State Significant Development Application for a Mixed Use Development at Site 9- Sydney Olympic Park (SSD 7445) - Notice of Exhibition

Thank you for your letter dated 21 April 2016 regarding the above. TfNSW has reviewed the supporting documentation and provides the following comments and condition of consent in relation to the proposal:

Mark Ozinga
Principal Manager Land Use Planning & Development
Transport Strategy

Figure 10 – Walking and Cycling Network (Source: Sydney Olympic Park Masterplan 2030)

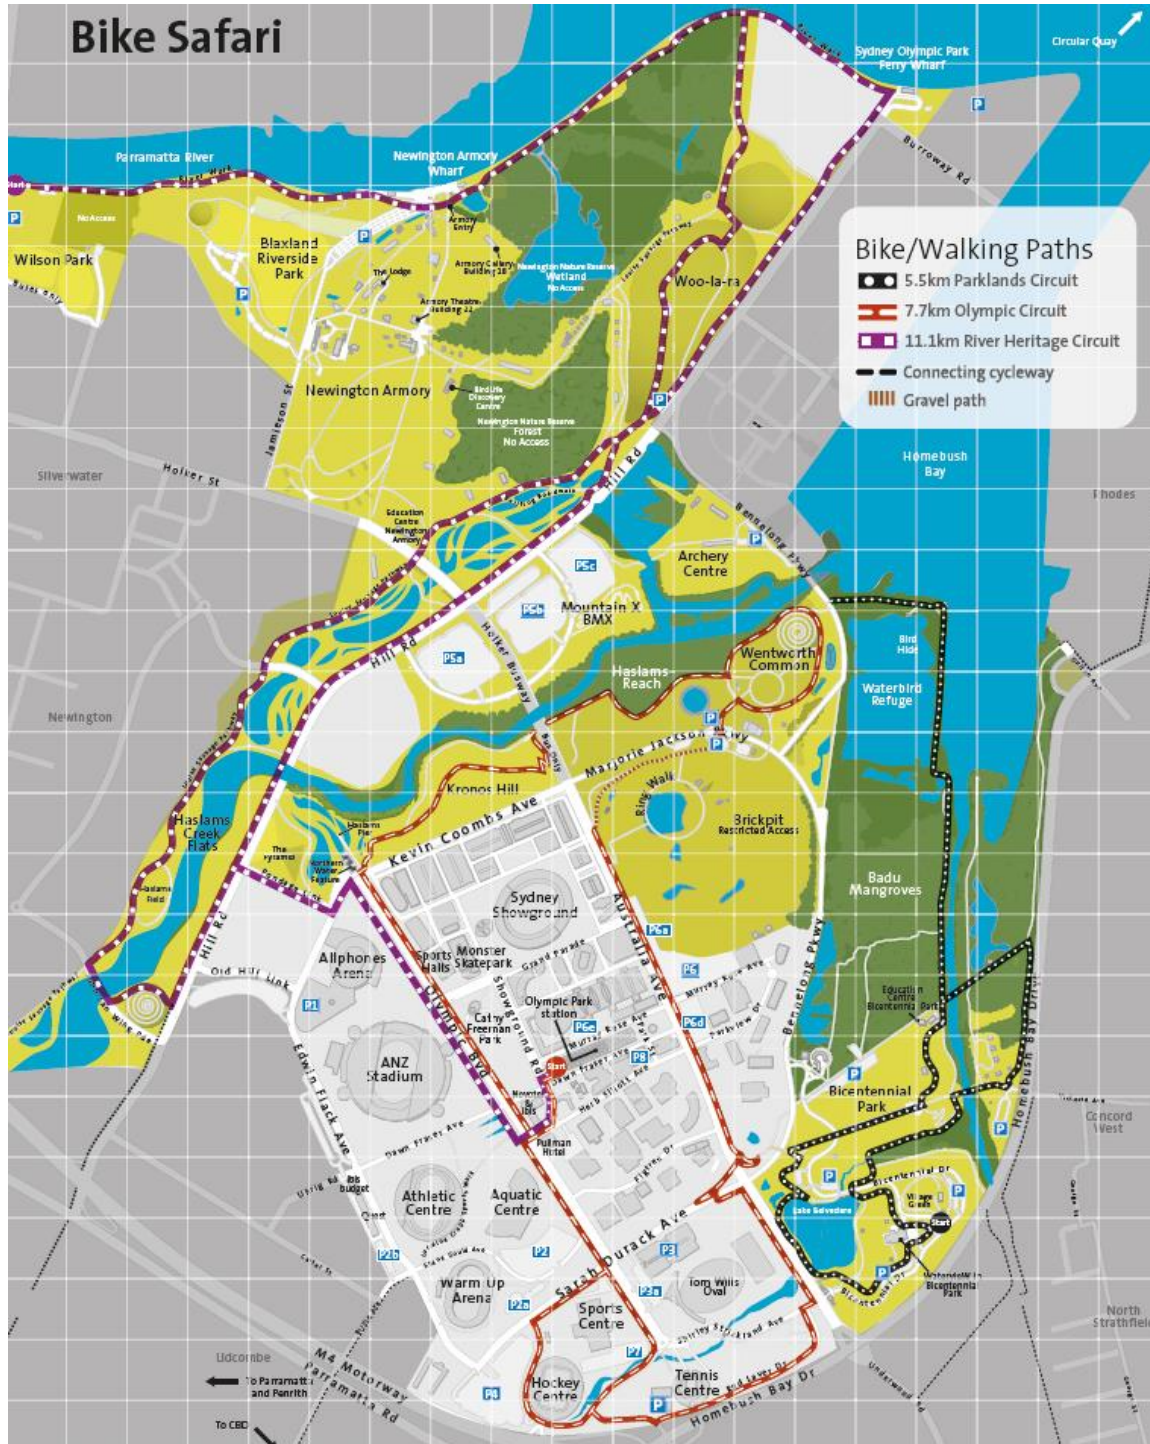
- Consider existing and future demands, total daily and peak hour walking and cycling trips surrounding the proposed site.
- Update figures of the existing walking and bicycle networks as per Sydney Olympic Park Authority (SOPA), Master Plan 2030 and the Auburn Cycle- map 2004.
